# HERBATA DATA CENTRE, NAAS - RESPONSE TO REQUEST FOR FURTHER INFORMATION ("RESPONSE TO RFI") FROM KILDARE COUNTY COUNCIL

## ADDENDUM TO CHAPTER 4 DESCRIPTION OF THE PROJECT AND NEED FOR THE PROJECT

NI2615  
01  
June 2025

1 A1400 - PROPOSED BOUNDARY AND FENCING PLAN
1 : 2000

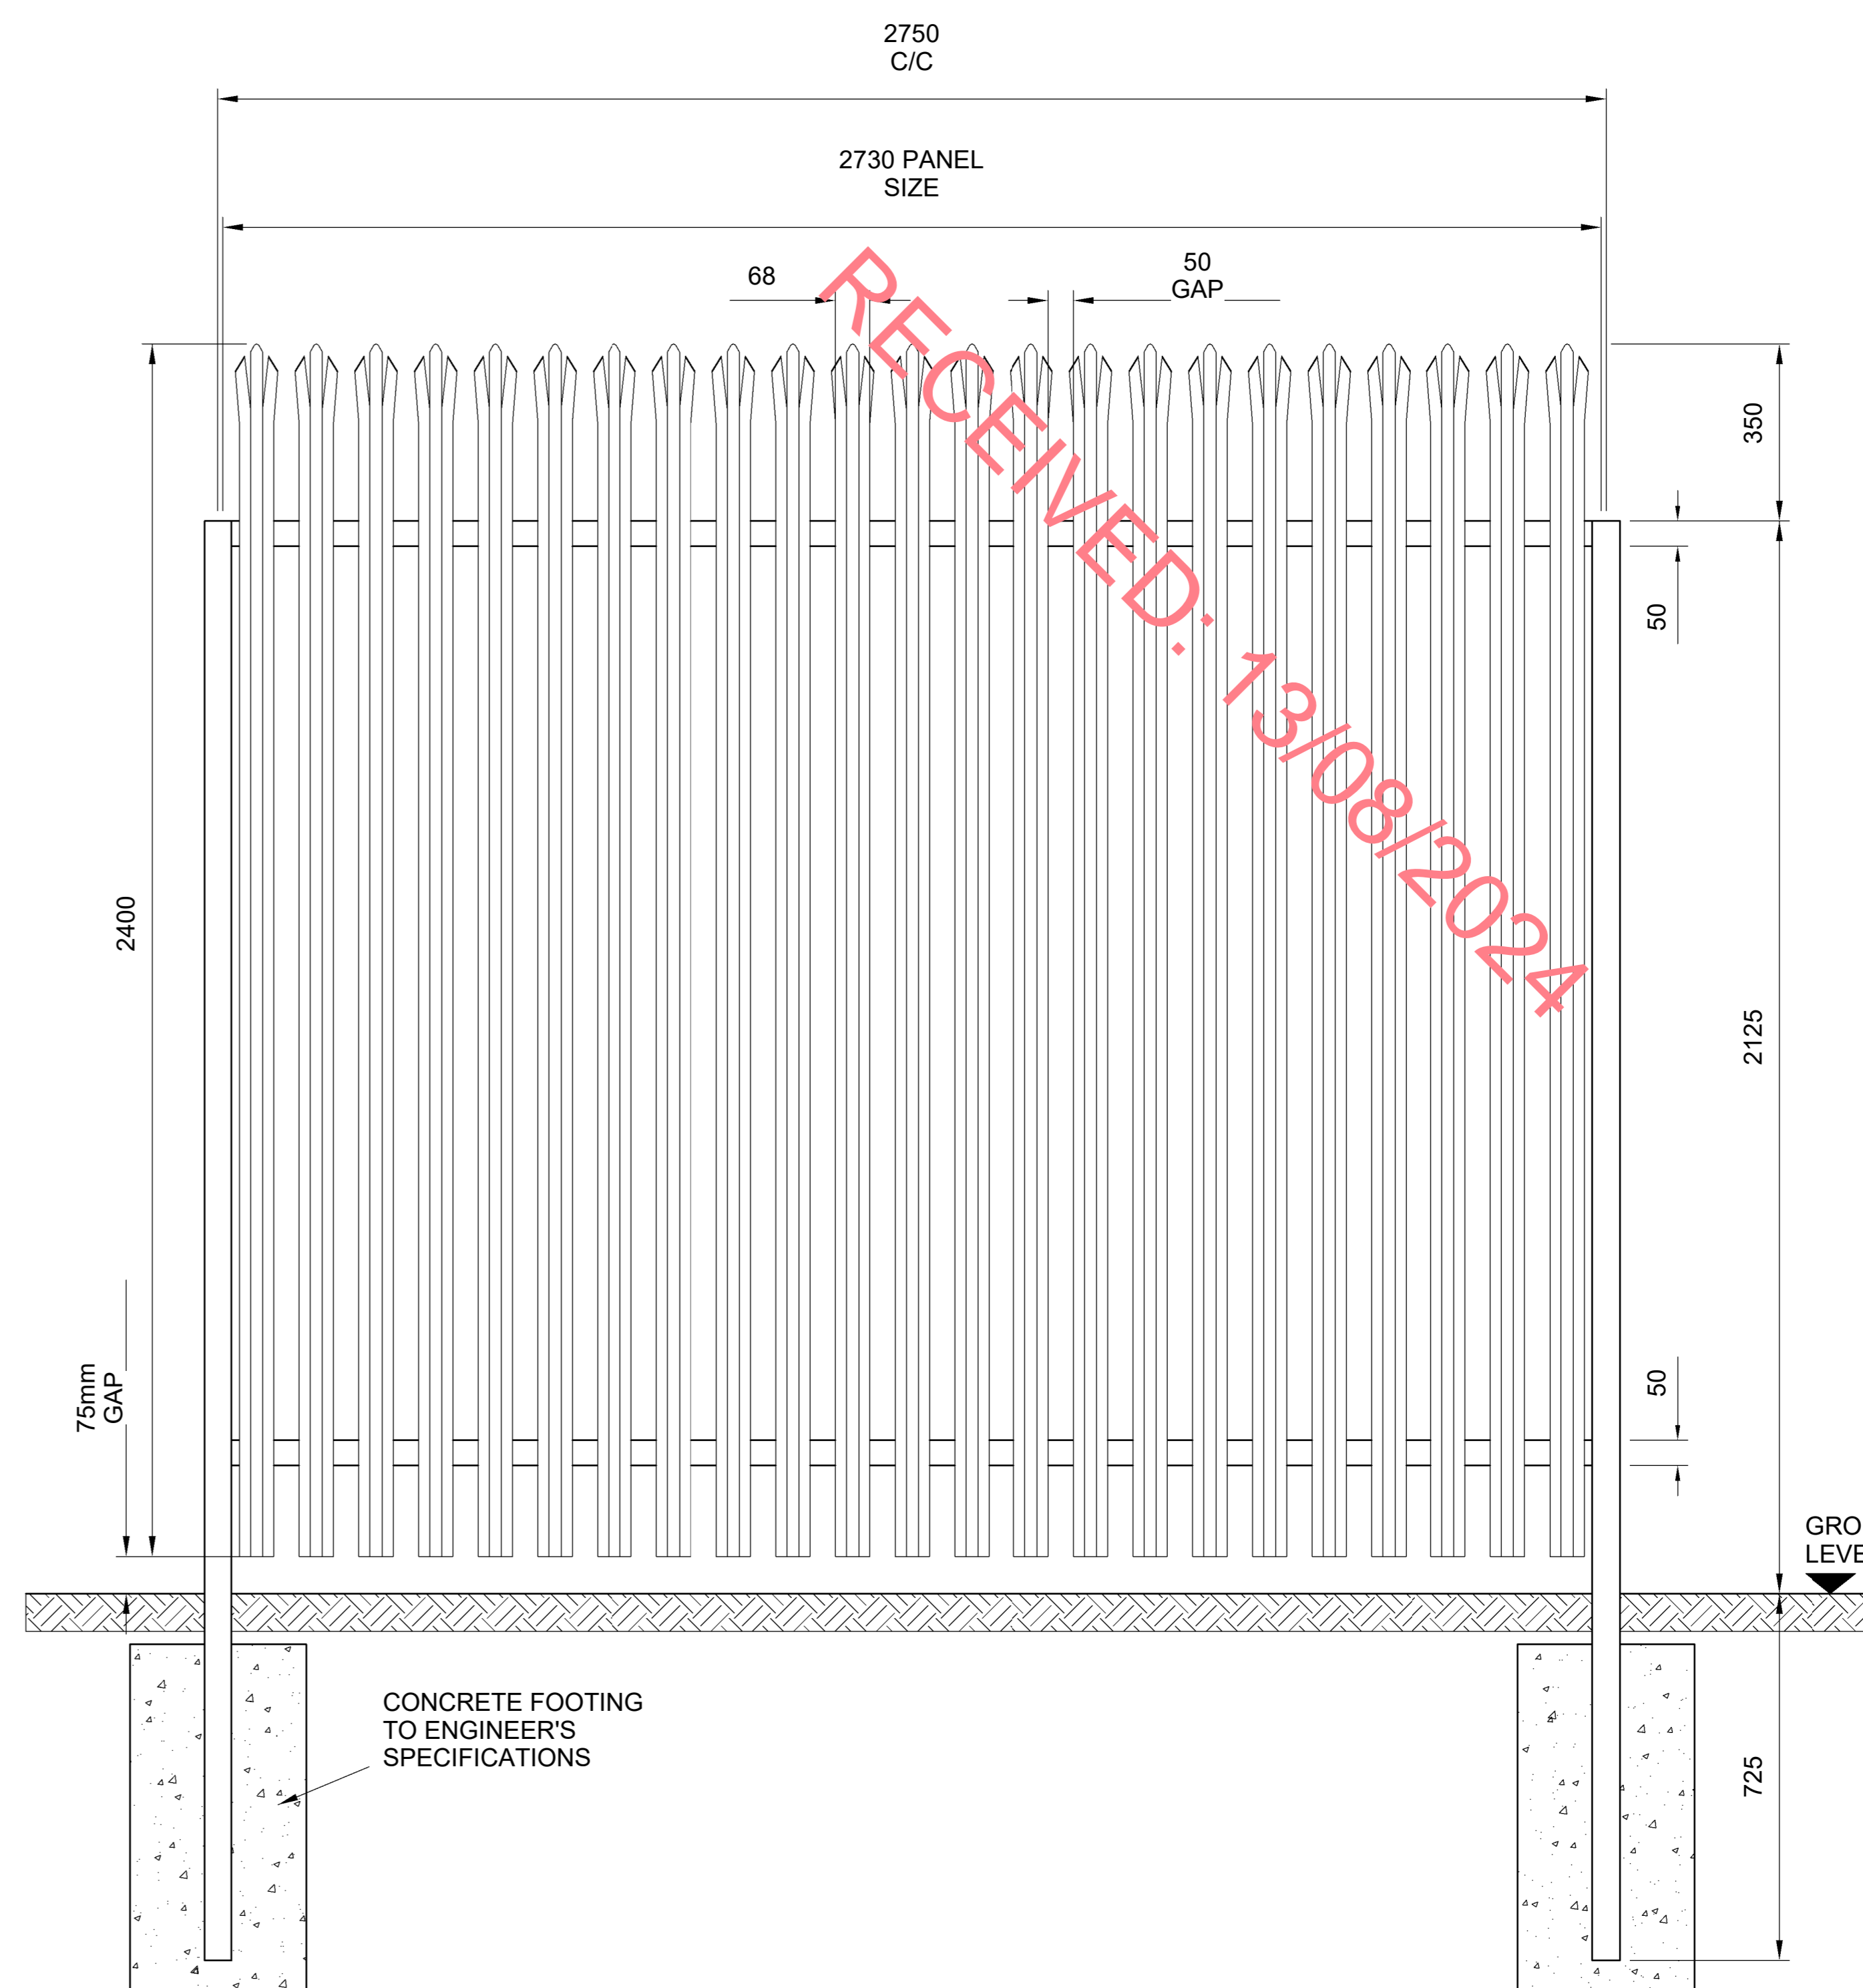
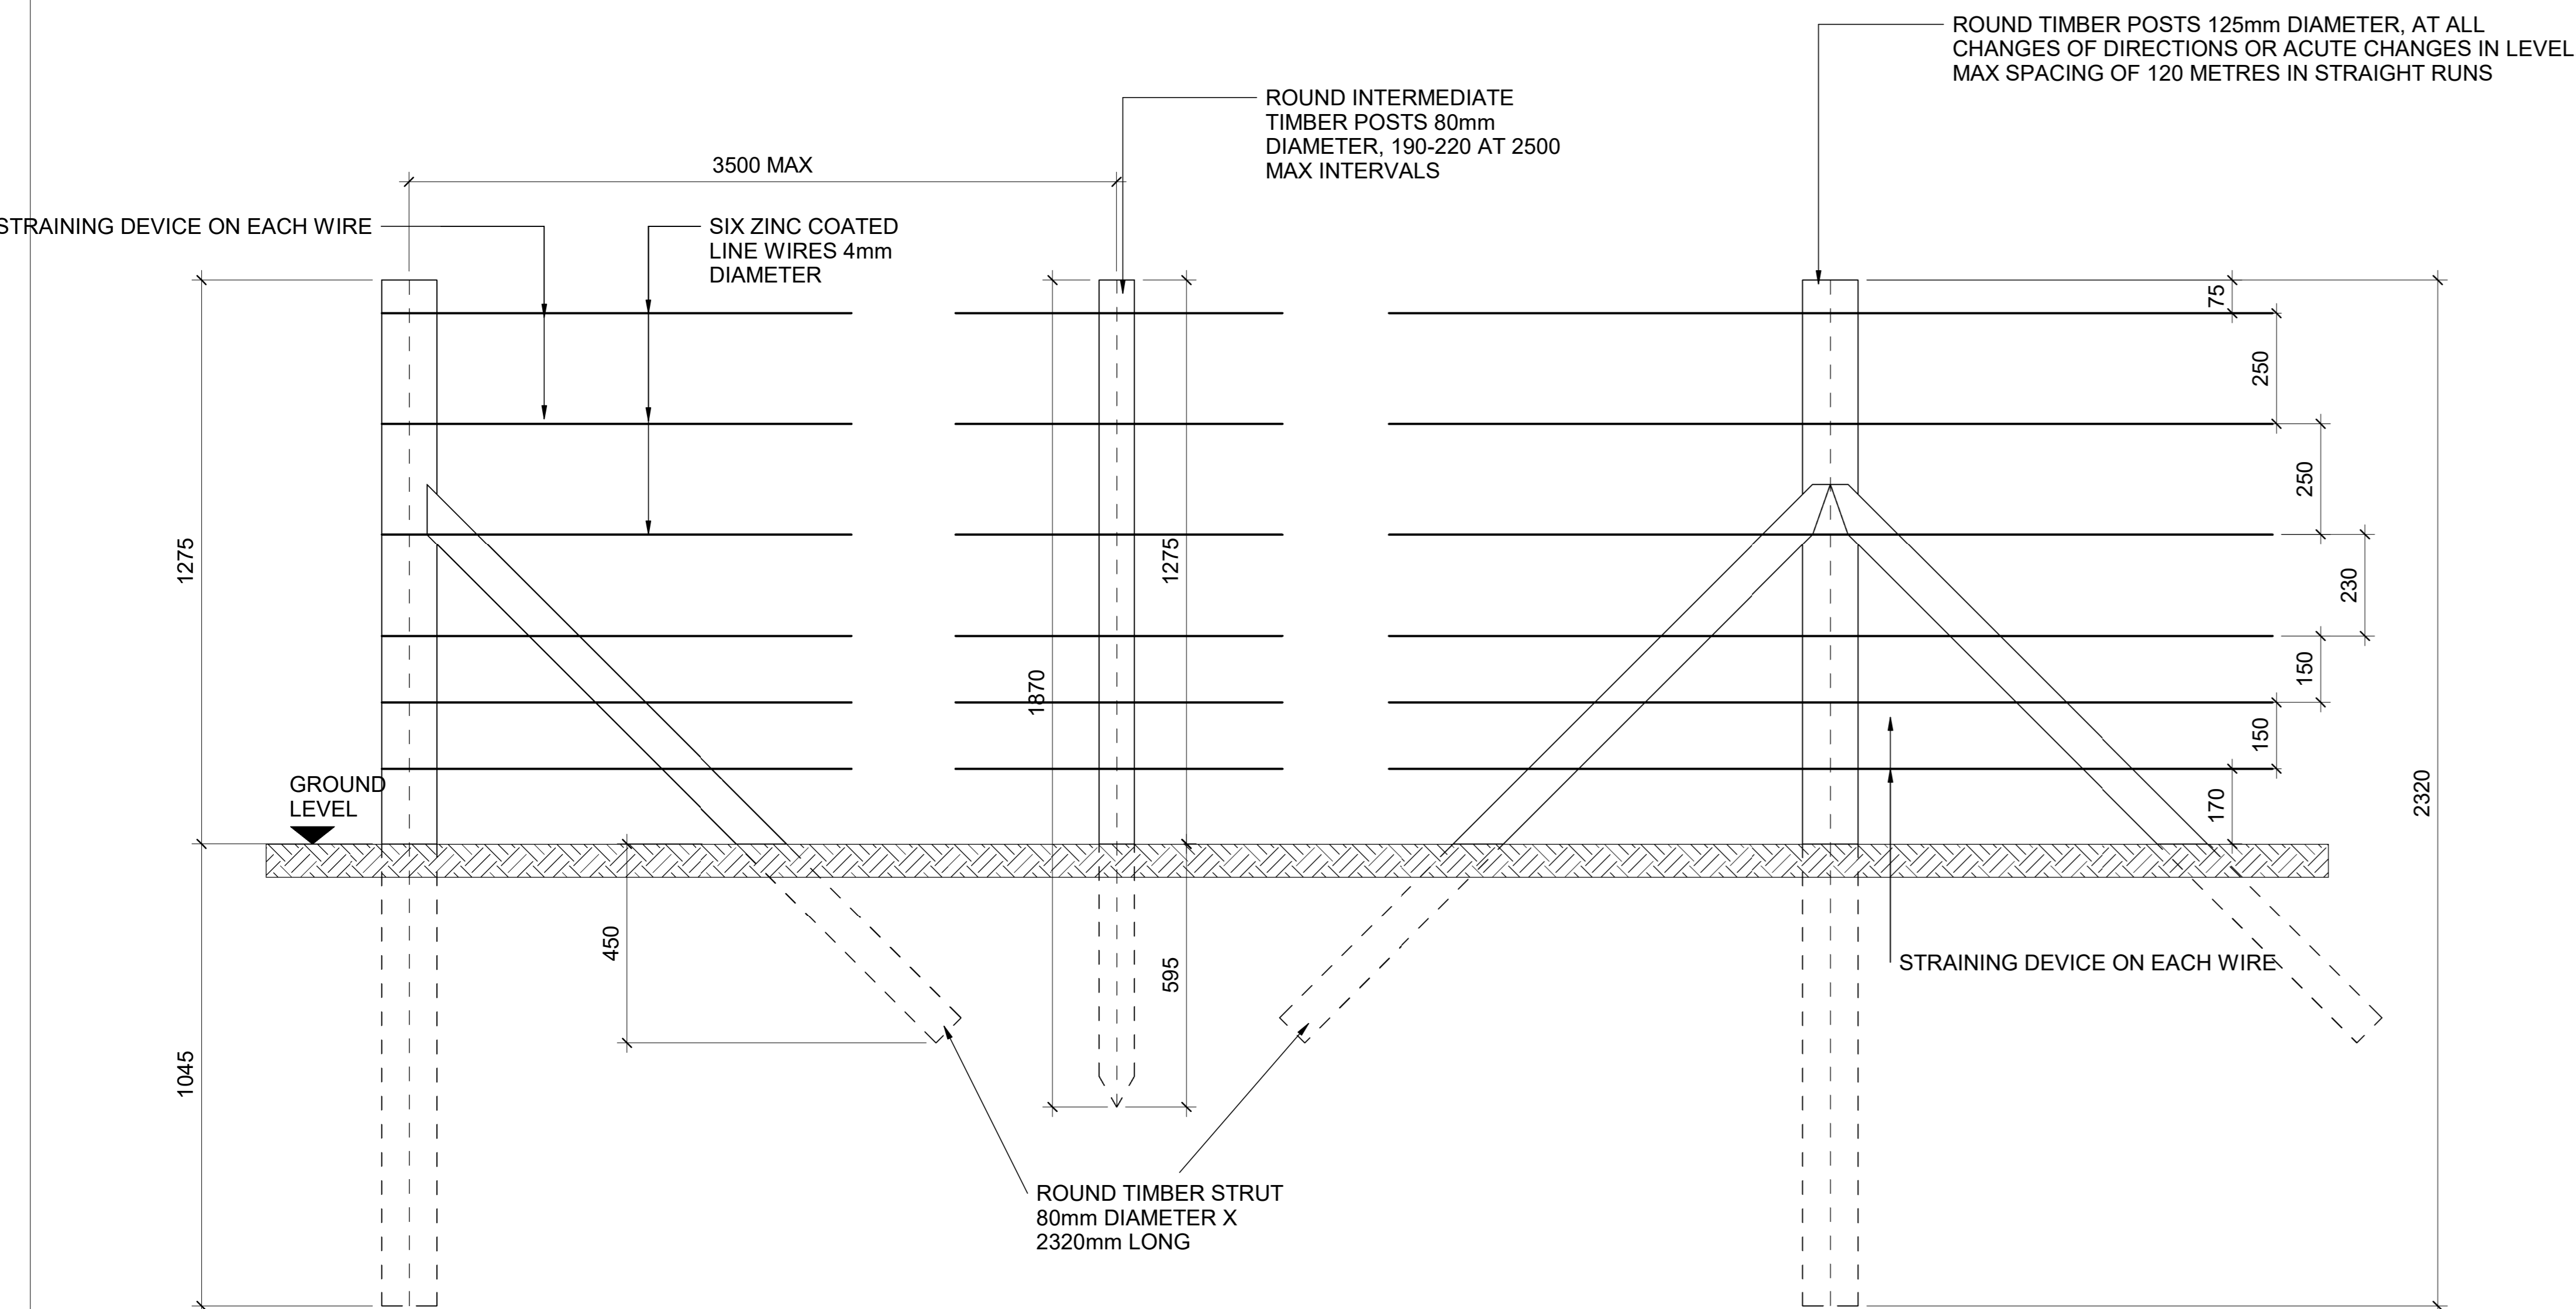
In consideration of the request for inclusion of a fencing arrangement *to allow for wildlife access and passage through the site*, an amendment has been made to the proposed Landscape Masterplan to include mammal passes in fences throughout the full extent of the site. The number, location and dimensions of the mammal passes was established following engagement between the project ecology and landscape team. The inclusion of the mammal passes has not required changes to the submitted landscape planting proposals.

Mammal passes are proposed at locations throughout the site including all *perimeter* fences and *internal* fences within the site (for example around each Data Centre building). A gap at the foot of the proposed fencing, of 500mm (width) x 200mm is determined sufficient for all potential mammal species and should ensure access and passage throughout the site. There are no proposed amendments to the overall height, materials or layout of the proposed fencing.

Figure 4.10 below (extract of drawing number BSM-ZZ-ZZ-DR-L-0311 Landscape Boundary Treatments Plan) illustrates the location of the mammal passes; Figure 4.11 below (extract of drawing number 22217-RKD-ZZ-ZZ-DR-A-1400 Proposed Boundary and Fence Details) illustrates the detailed dimensions of the fencing.
